October 2, 2019

Re: Ti and Addition
2409 Princeton Ave NE
Traffic Circulation Layout
Engineer's/Architect's Stamp 09-20-2019 (H16D125)

Based upon the information provided in your submittal received 09-25-2019, the above referenced plan cannot be approved for Building Permit until the following comments are addressed:

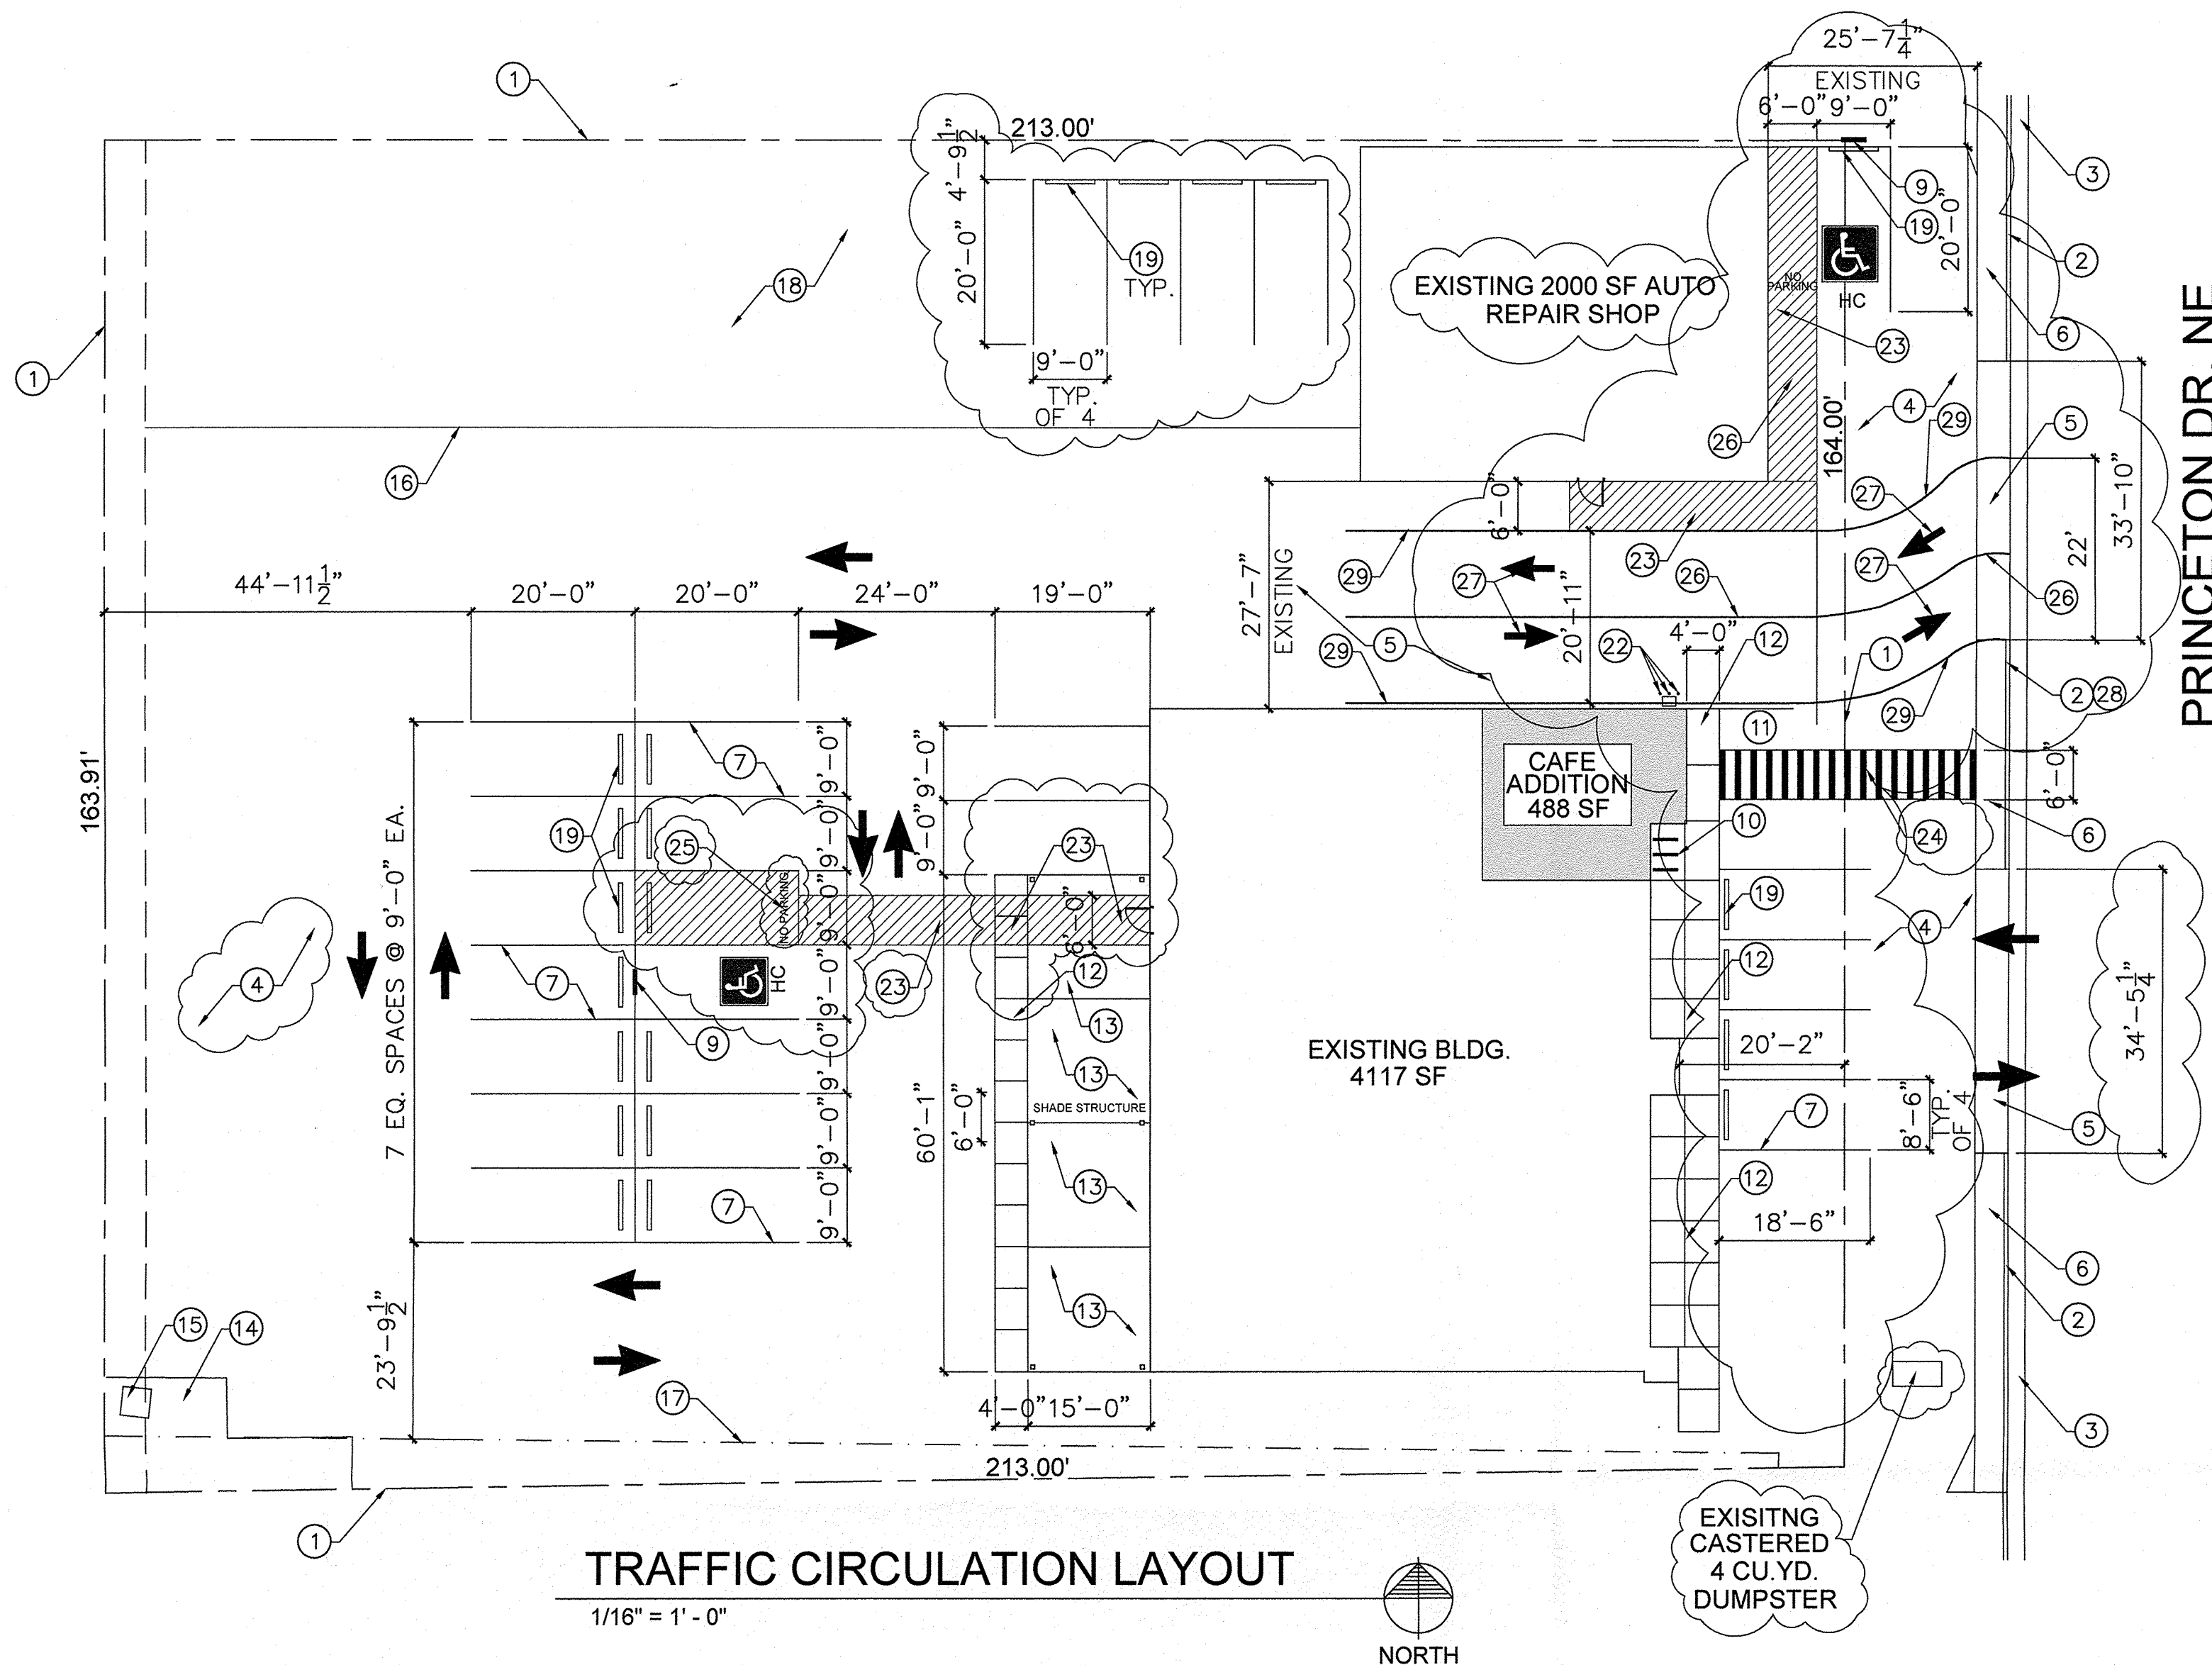
1. The site access through Princeton Dr. should be moved to the south because there is a storage building in front of it.
2. Label the compact parking spaces by placing the words "**COMPACT**" on the pavement of each space.

3. The ADA access aisles shall have the words "**NO PARKING**" in capital letters, each of which shall be at least one foot high and at least two inches wide, placed at the rear of the parking space so as to be close to where an adjacent vehicle's rear tire would be placed. (66-1-4.1.B NMSA 1978)

4. Motorcycle parking spaces shall be designated by its own conspicuously posted upright sign, either free-standing or wall mounted per the zoning code.

5. All bicycle racks shall be designed according to the following guidelines:
 - a. The rack shall be a minimum 30 inches tall and 18 inches wide.
 - b. The bicycle frame shall be supported horizontally at two or more places. Comb/toaster racks are not allowed.

- c. The rack shall be designed to support the bicycle in an upright position. See the IDO for additional information.
 - d. The rack allows varying bicycle frame sizes and styles to be attached.

- e. The user is not required to lift the bicycle onto the bicycle rack.
 - f. Each bicycle parking space is accessible without moving another bicycle.

6. Bicycle racks shall be sturdy and anchored to a concrete pad.
7. A 1-foot clear zone around the bicycle parking stall shall be provided.

8. Bicycle parking spaces shall be at least 6 feet long and 2 feet wide.
9. Per DPM, a 6 ft. wide ADA accessible pedestrian pathway is required from the ADA parking stall access aisles to the building entrances. Please clearly show this pathway and provide details.
10. You will need a revocable permit to access the parking spaces in front of the building. The other option would be to move those parking spaces to a different location if you don't want to get a revocable permit.
11. And the keyed note needs some attention. For example there are two 7's, numbers 20 and 21 is not shown on the plan, and number 6 is pointing to two different things.
